| <b>Application Ref:</b>            | 3/2026/0016 |                     |     | <br>Ribble Valley<br>Borough Council<br><a href="http://www.ribblevalley.gov.uk">www.ribblevalley.gov.uk</a> |
| <b>DELEGATED ITEM FILE REPORT:</b> |             |                     |     | <b>APPROVAL</b>  |

| <b>Development Description:</b> | Conversion of the existing garage to create an extra room, with widening of the driveway and dropped kerb, plus new windows to the side garage wall. |
| <b>Site Address/Location:</b>   | 34 Aspen Crescent, Barrow, BB6 9ZL.  |

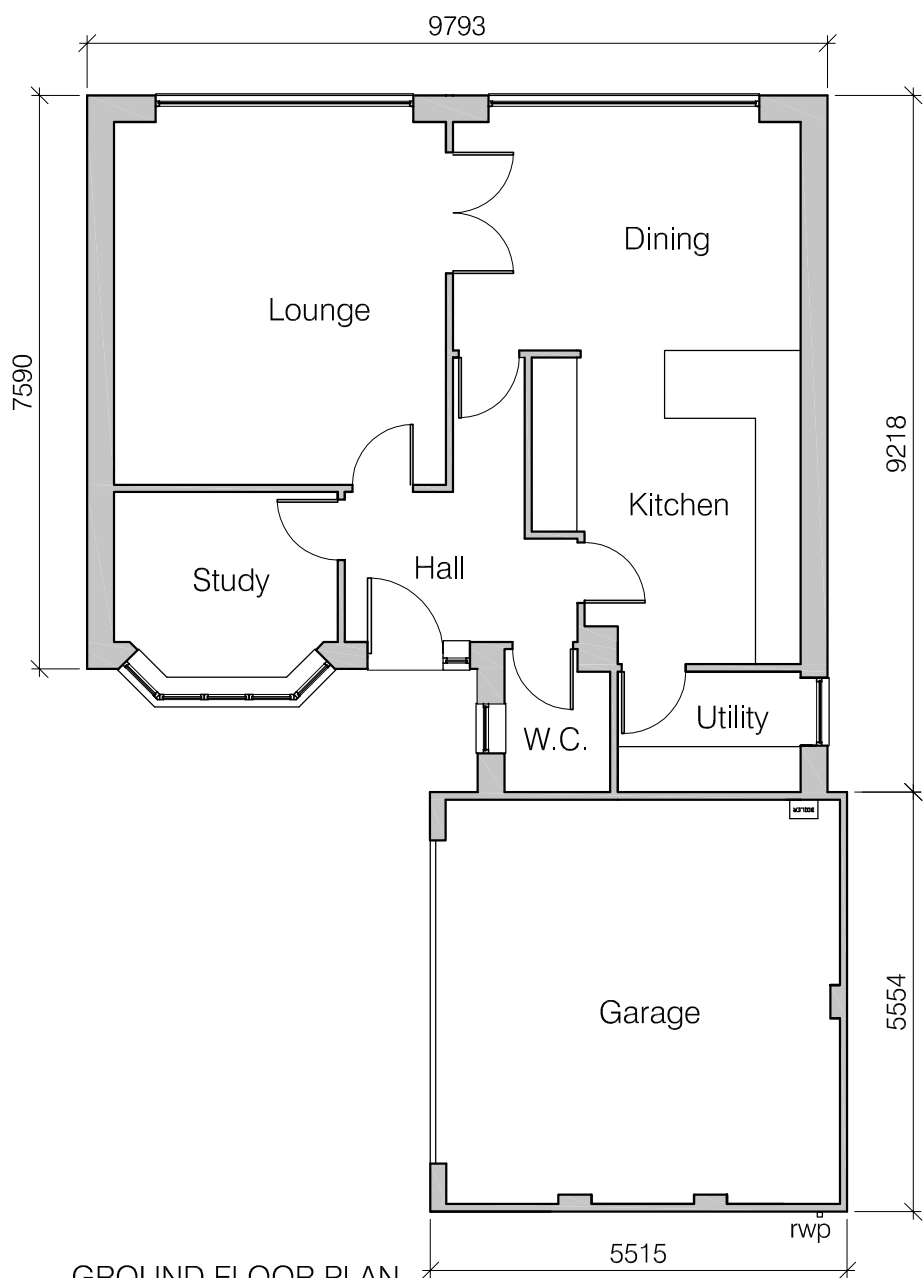
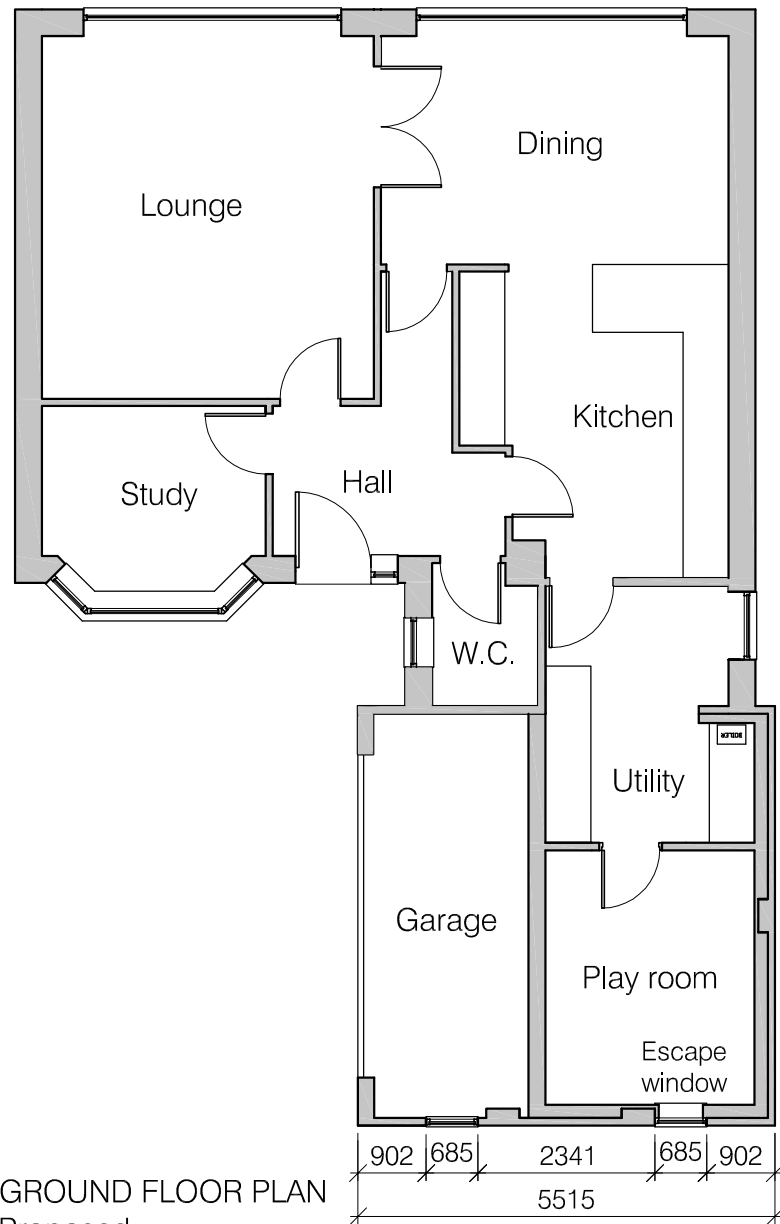
The new openings proposed to the eastern elevation of the garage would provide views towards No.32 Aspen Crescent. Despite this, a separation distance of 21m would be retained between the proposed windows and those featured to the front elevation of No.32 and therefore it is not considered that the development would result in any significant loss of privacy that would warrant the refusal to grant planning permission in this particular instance.

The development is not considered to result in any measurable adverse impact upon the existing visual amenities of the immediate or wider locality, insofar that the only external alterations proposed include the addition of 2no. small windows to the eastern elevation of the garage and the widening of the existing

Proposed block plan - 1:200

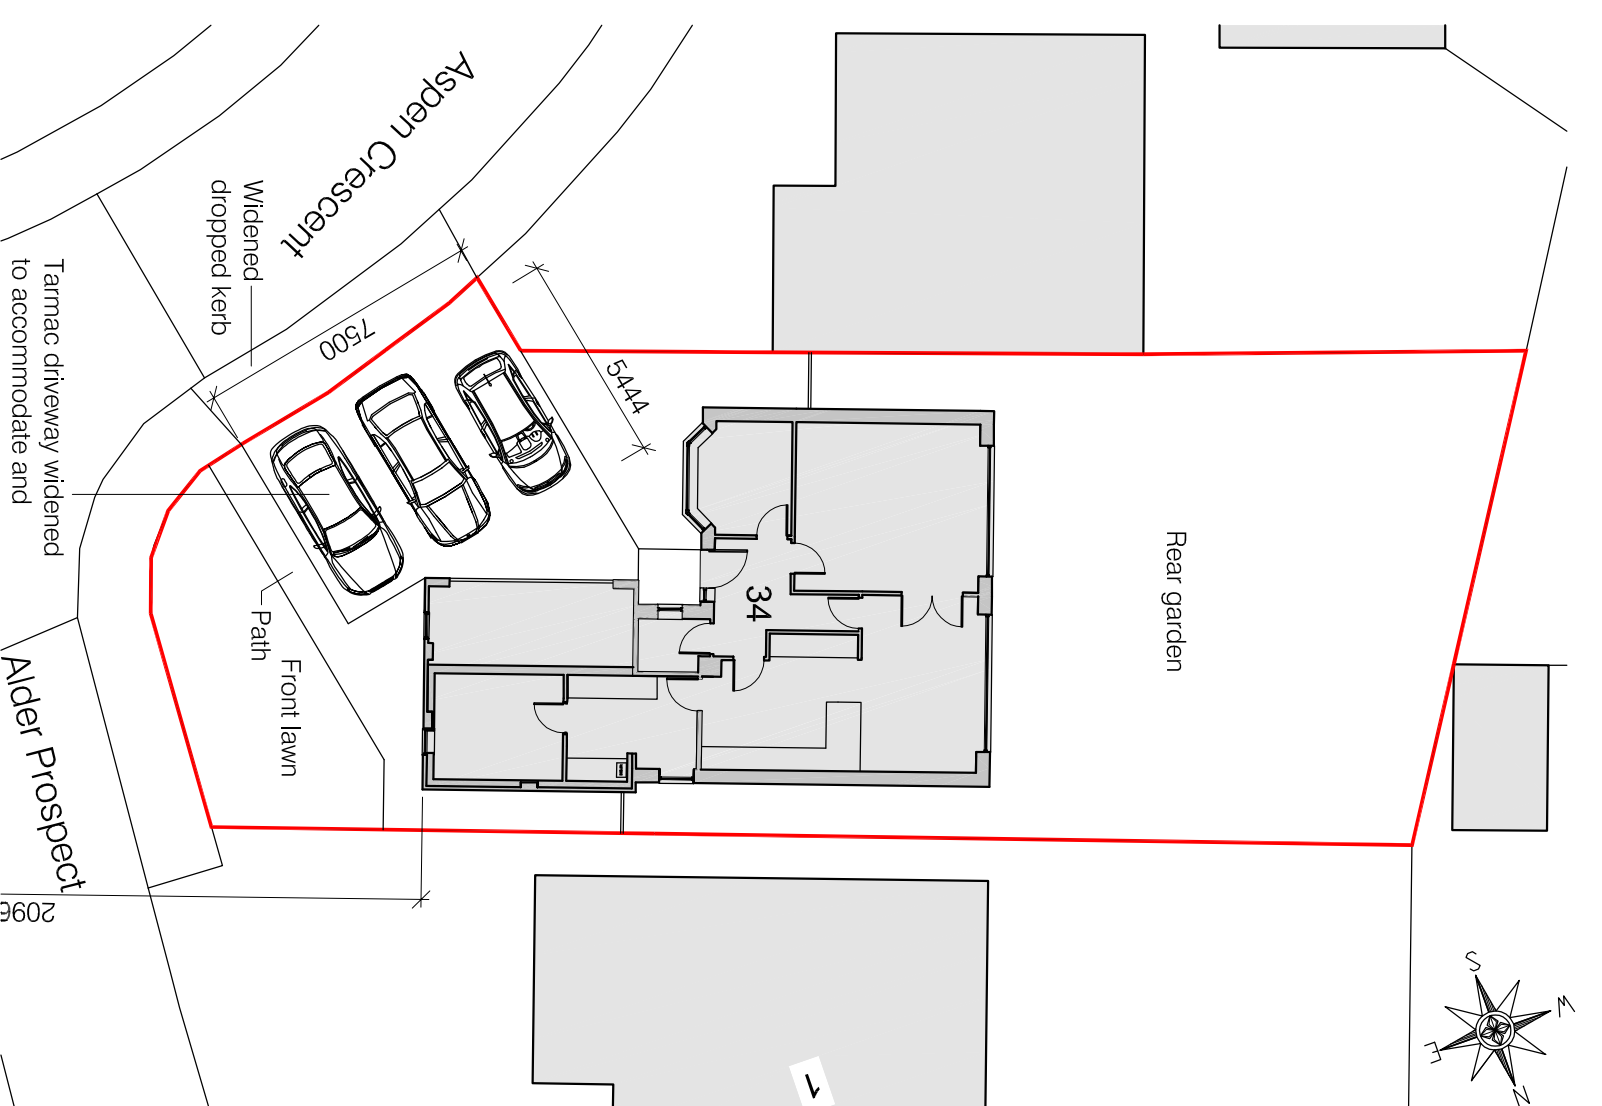
The proposal would involve the loss of the existing double garage; however, the existing driveway is proposed to be extended with the submitted Proposed Block Plan showing the provision of 3no. on-site parking spaces.

The proposed works have been subject to review by Lancashire Country Council Highways Authority who are of the view that the proposed development would not have a significant impact upon highway safety or capacity in the immediate vicinity of the site, subjection to the imposition of a condition requiring the extended driveway to be constructed prior to first use of the converted garage and paved in porous hard bound material. The development is therefore considered acceptable with respect to highway safety and parking.
